2280.08-DRAWING REVISION SCHEDULE

2 SECTION-HEIGHT PLANE 1
Scale: 1 : 500

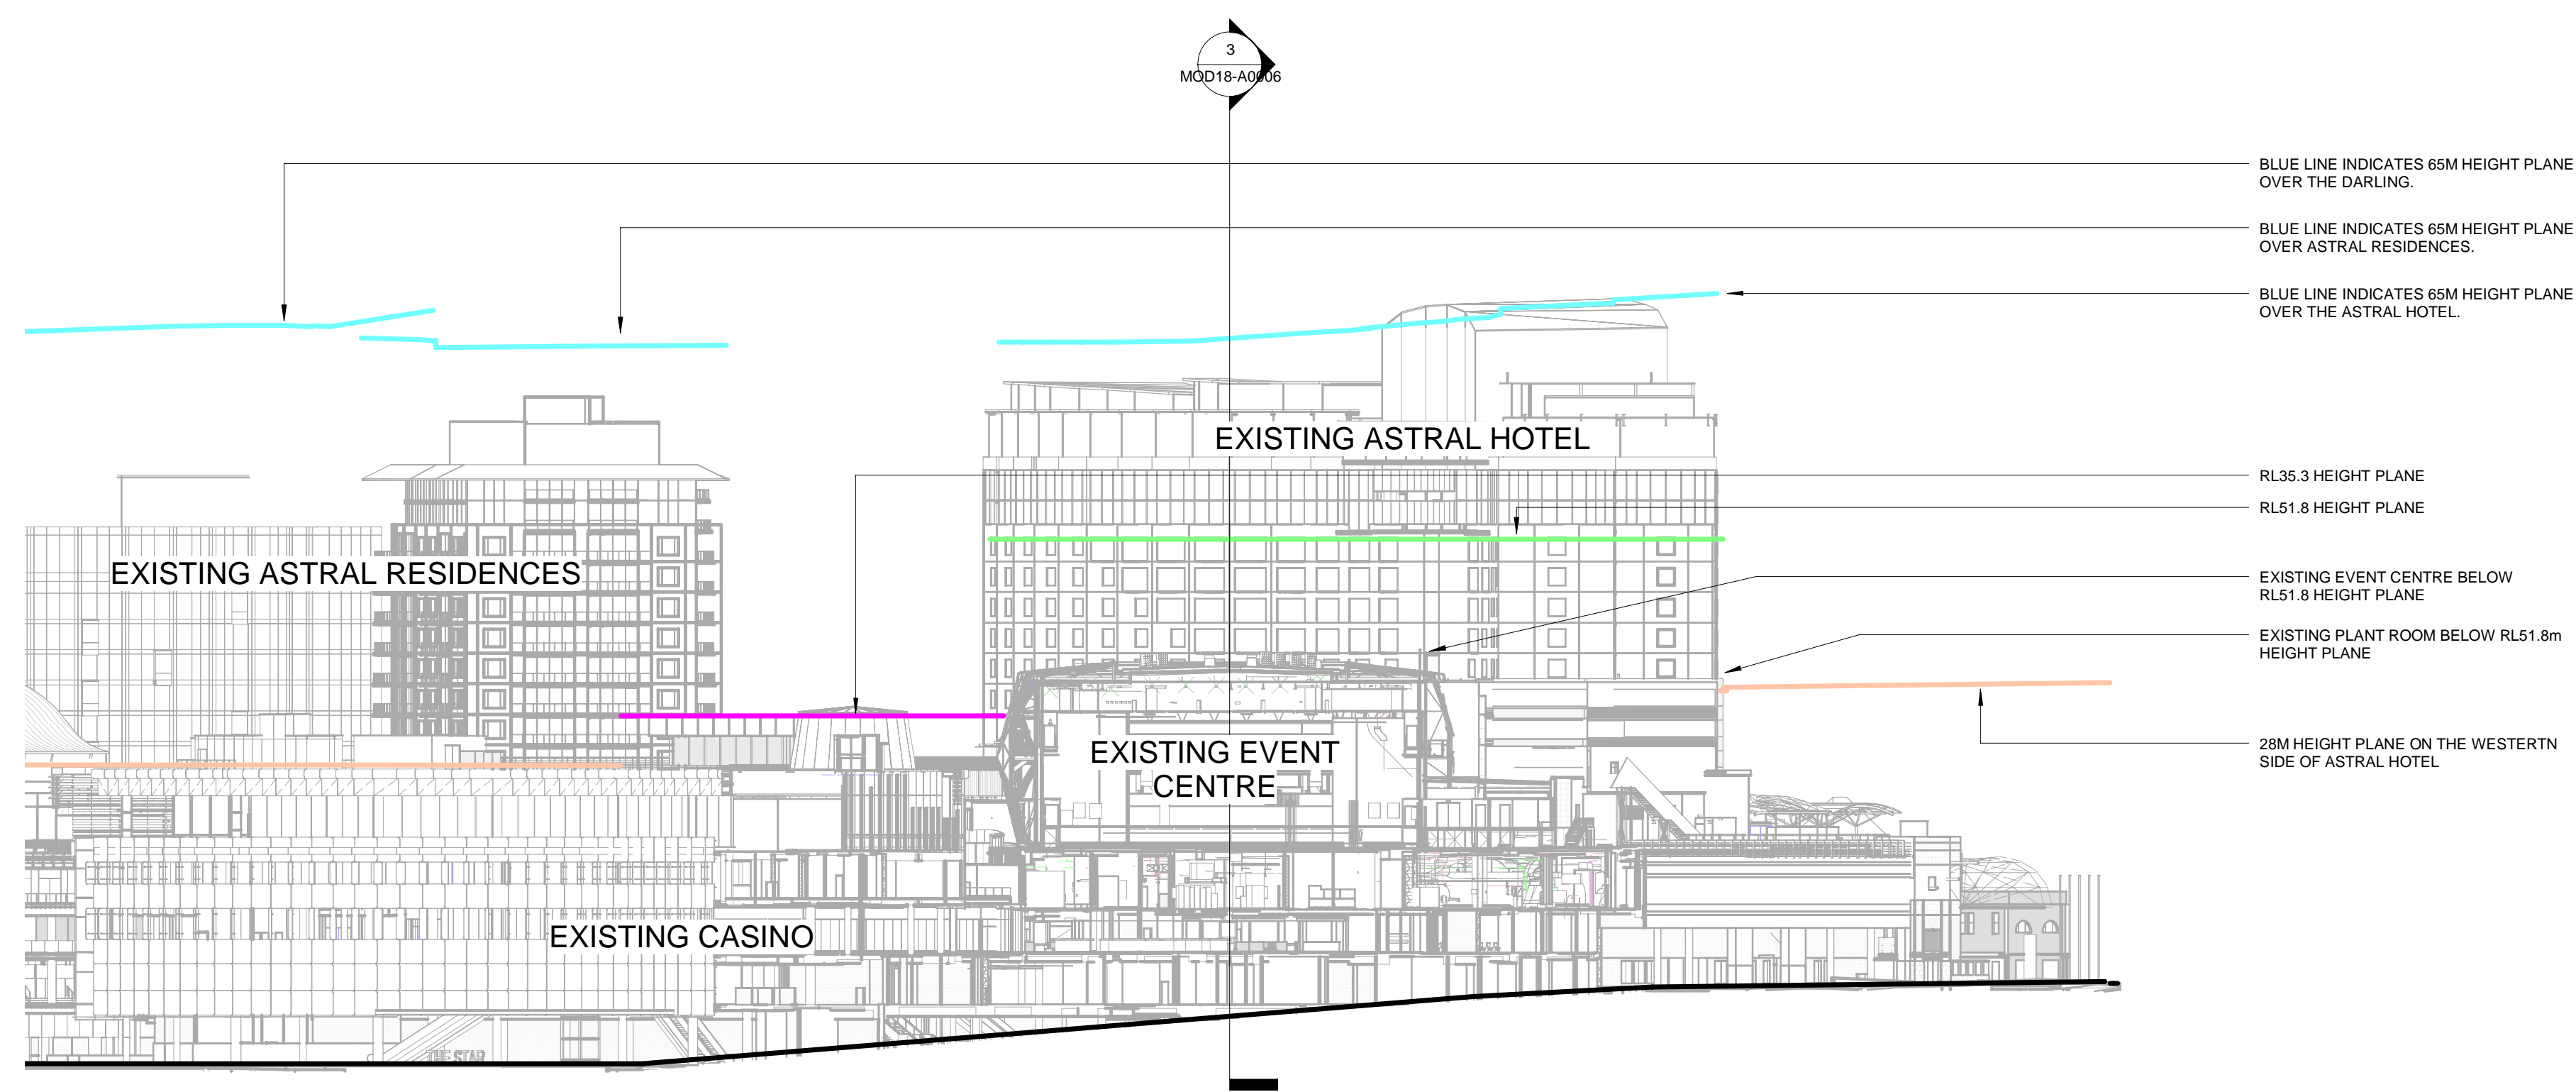
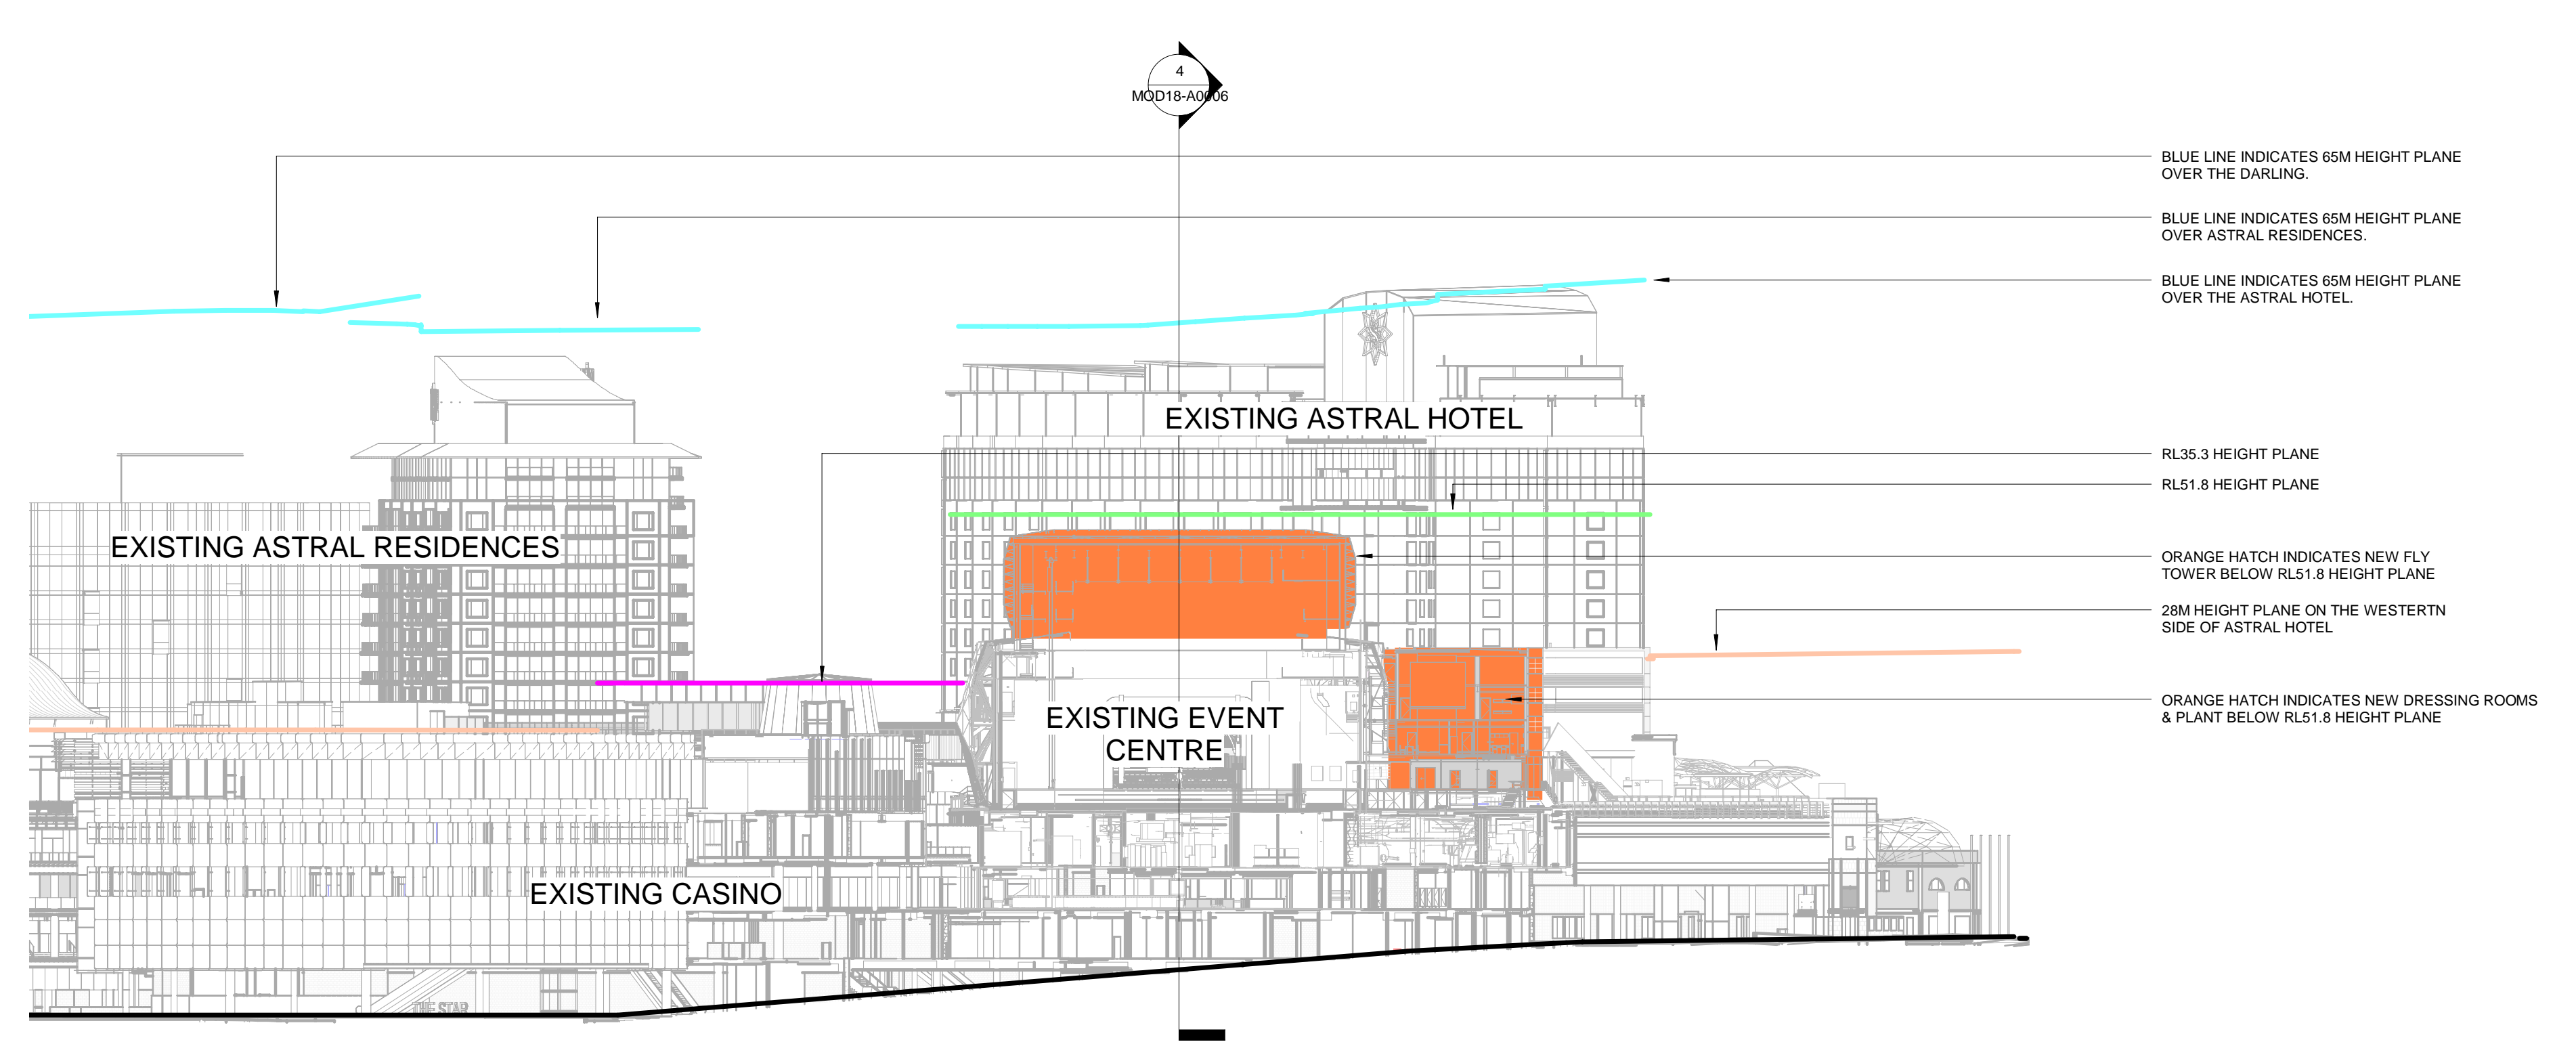
1. 28m and 65m height planes separated to clarify extent of the various height planes on the site.
2. New RL35.3, RL51.8 and RL110m height planes added to suit current LEP.

3. Footprint of fly tower reduced to suit comments from DPE and City of Sydney.
4. 4 level extension over existing dressing rooms reduced to 3 levels over existing dressing rooms. Aluminium clad screen extending from 4 level extension and on front of existing plant room omitted.
5. Double height plant room extension omitted from scope.
6. 28m and 65m height planes separated to clarify extent of the various height planes on the site.
7. New RL35.3, RL51.8 and RL110m height planes added to suit current LEP.

4 SECTION-HEIGHT PLANE 3
Scale: 1 : 500

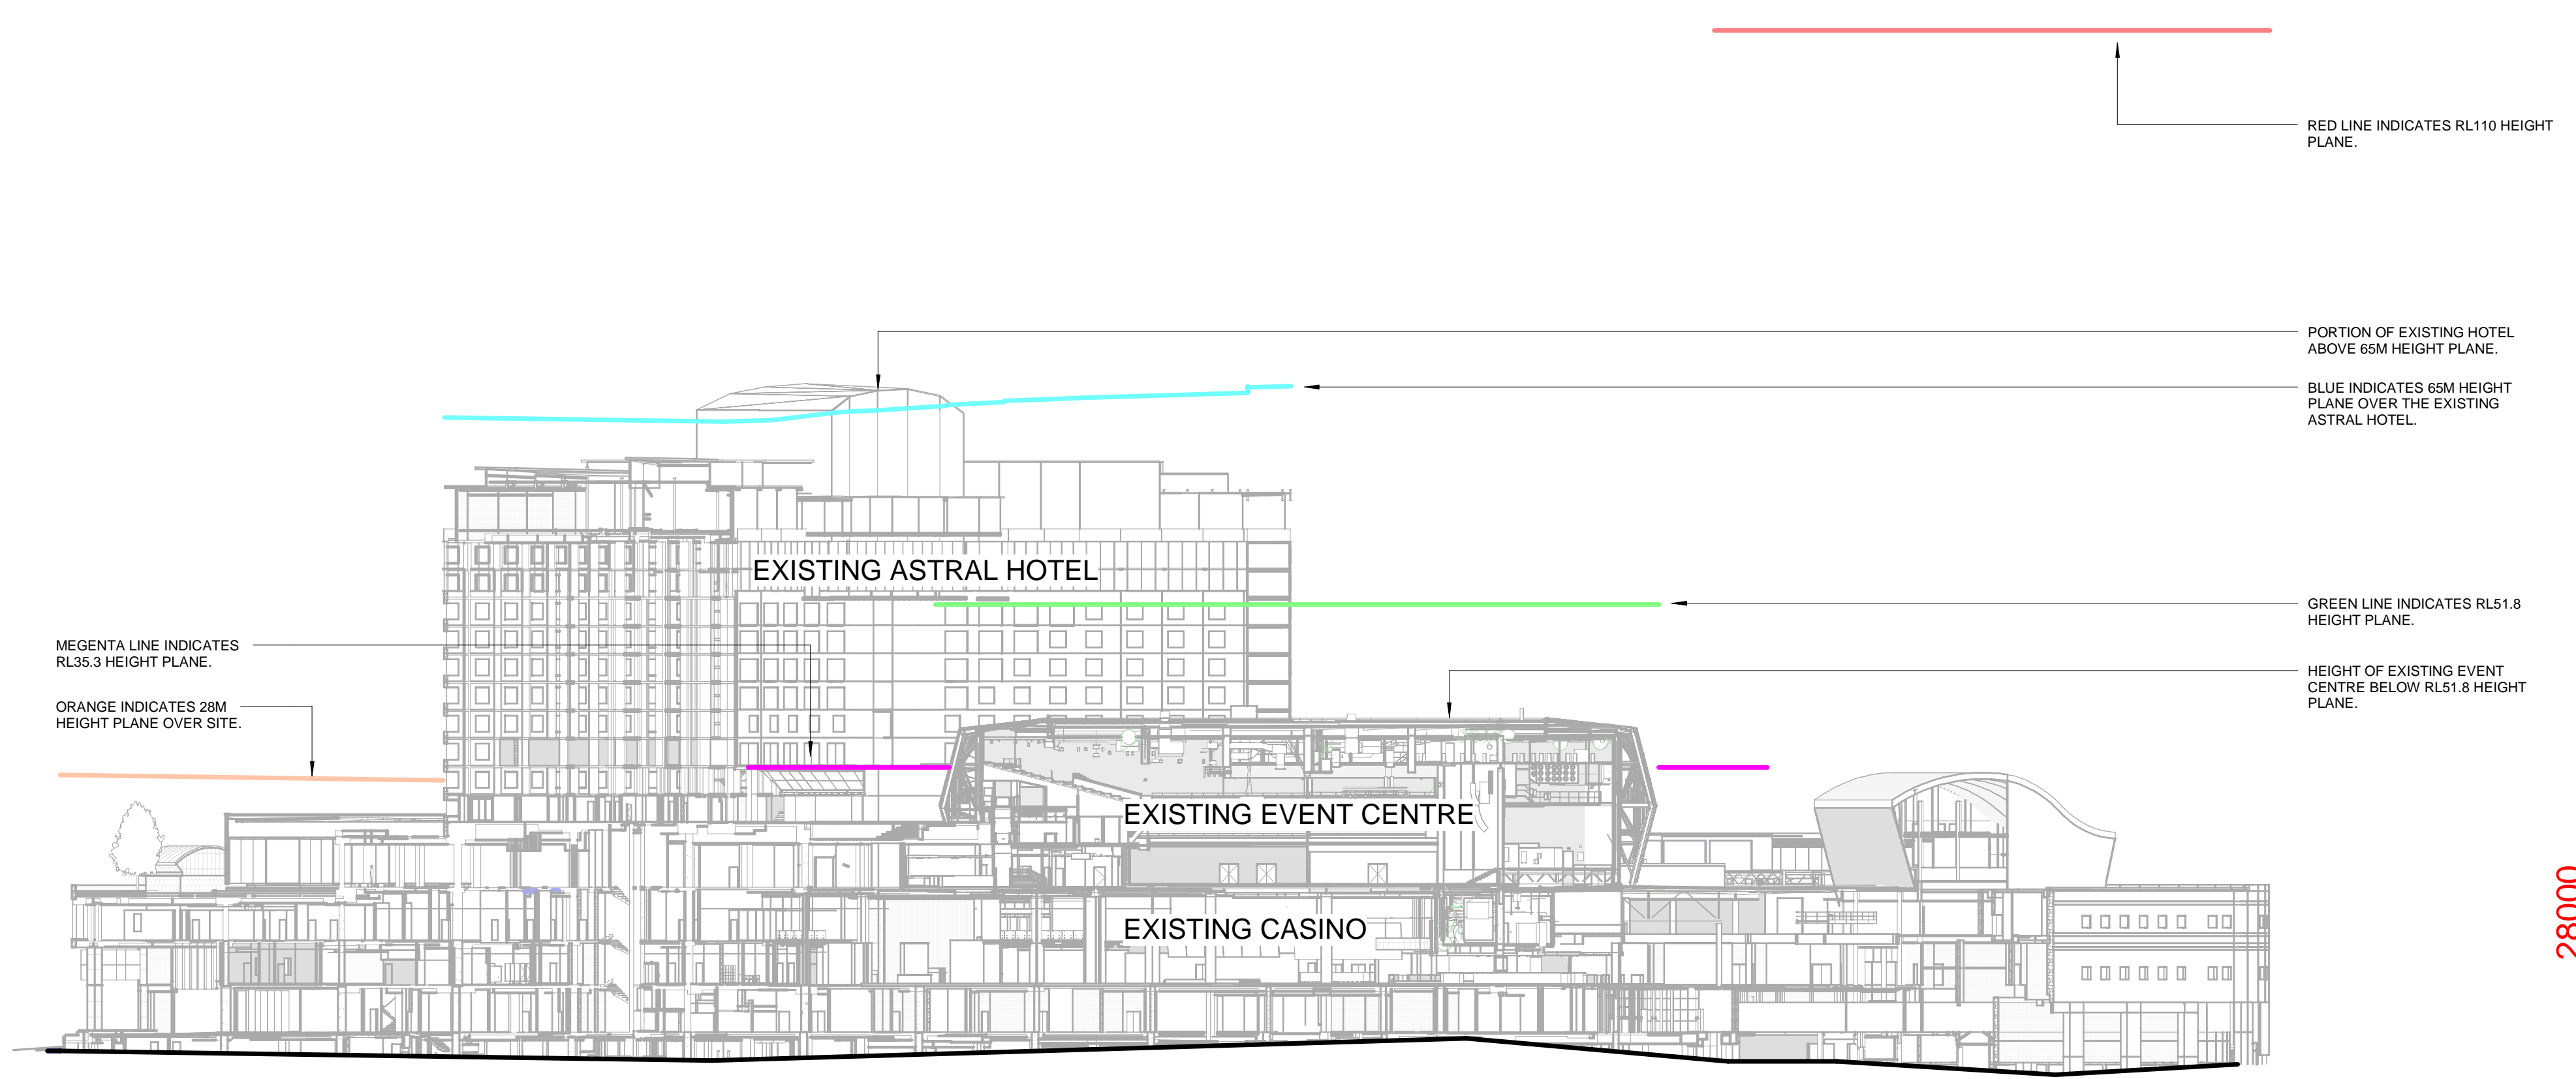
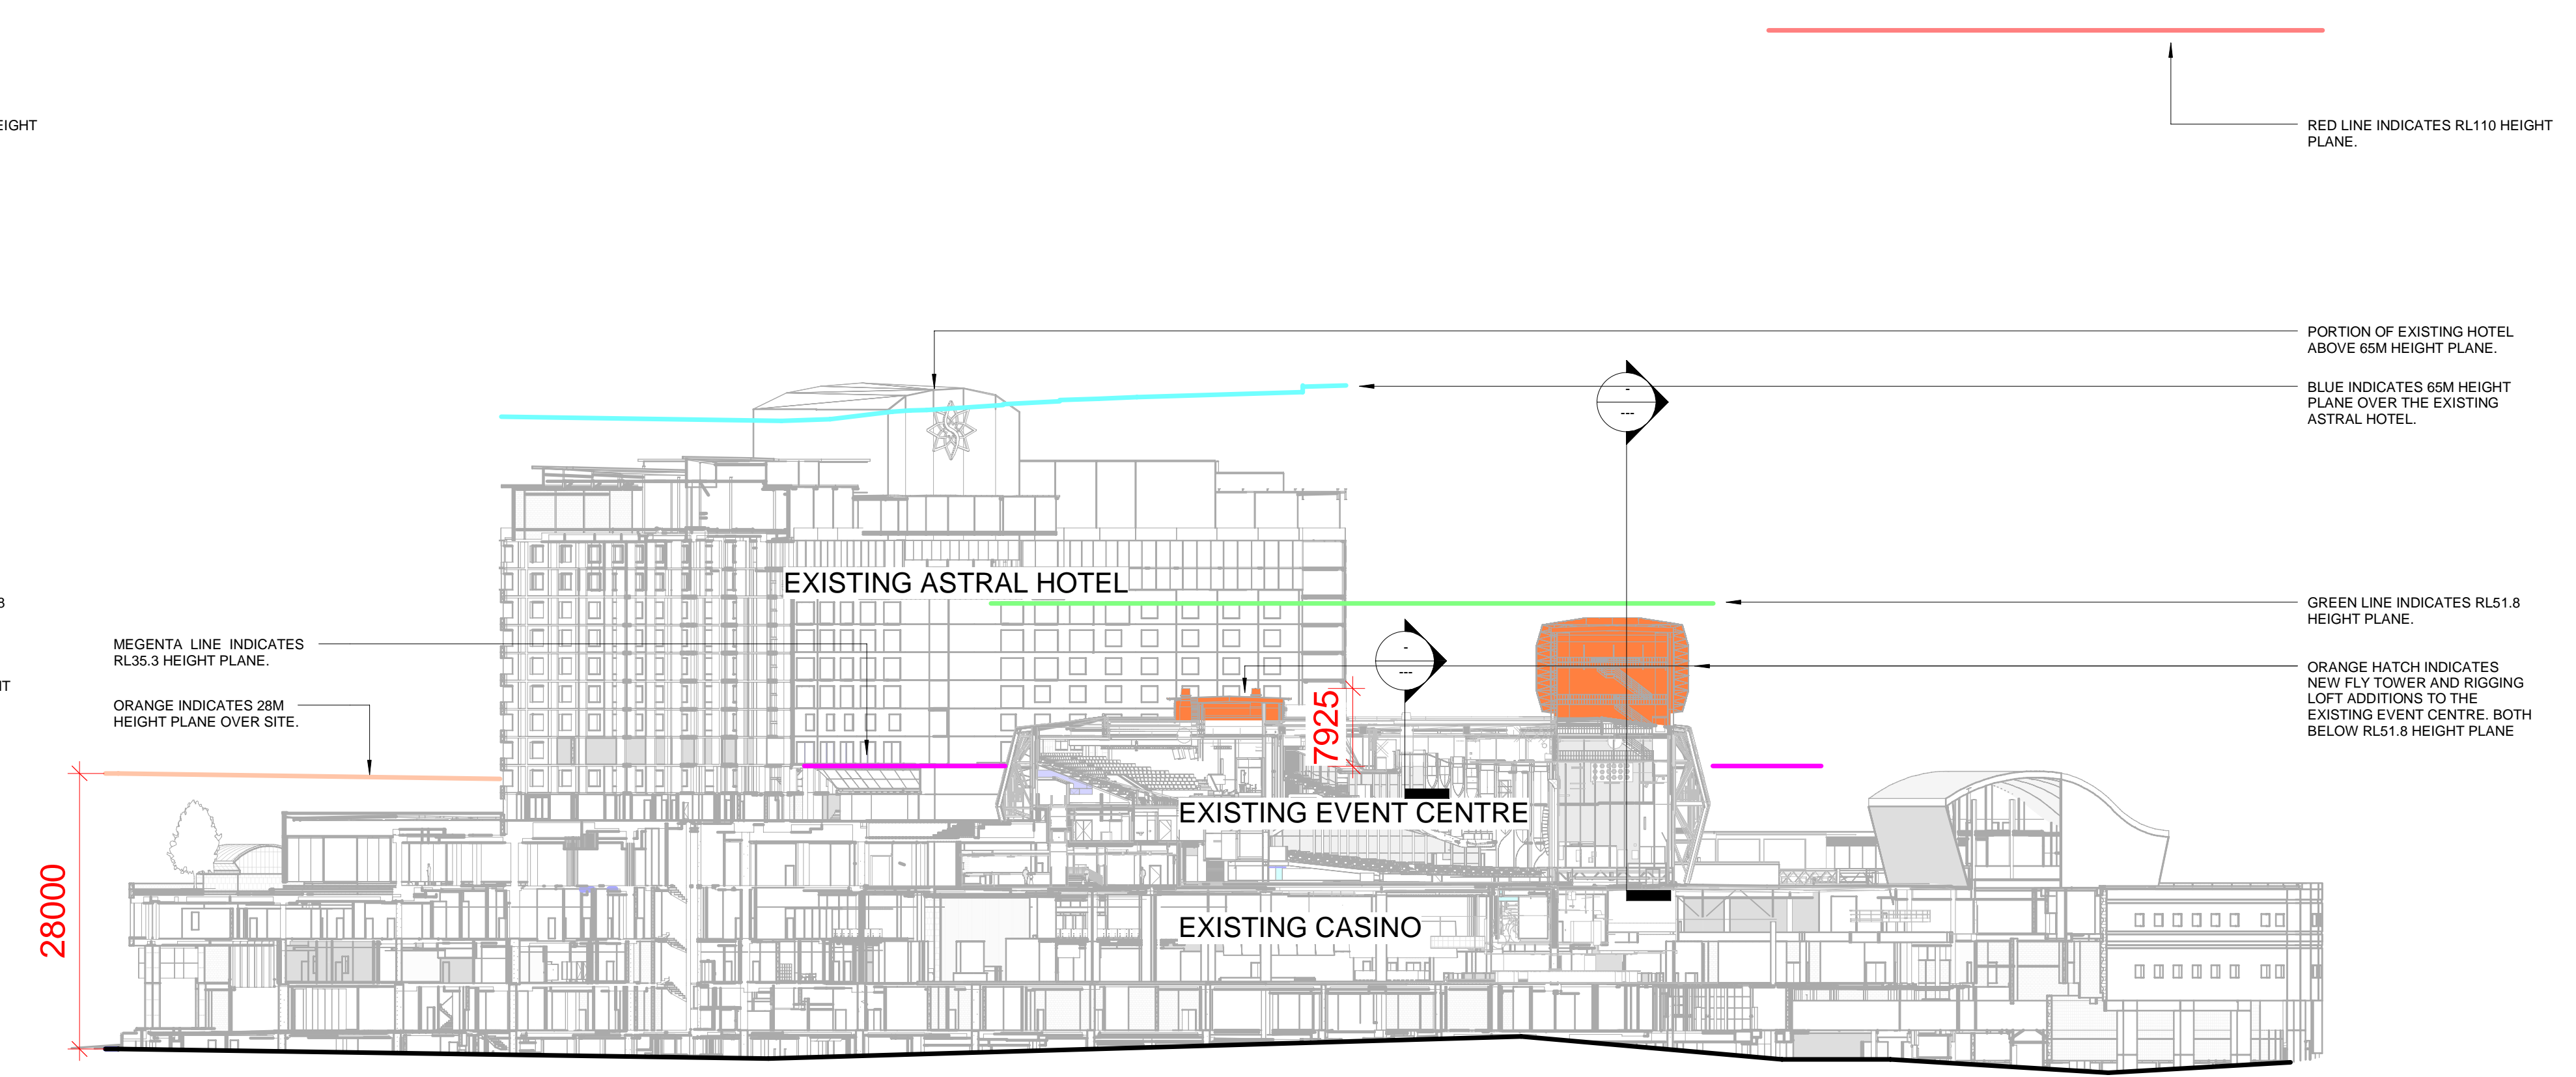
1. Footprint of fly tower reduced to suit comments from DPE and City of Sydney.
2. 28m and 65m height planes separated to clarify extent of the various height planes on the site.
3. New RL35.3, RL51.8 and RL110m height planes added to suit current LEP.
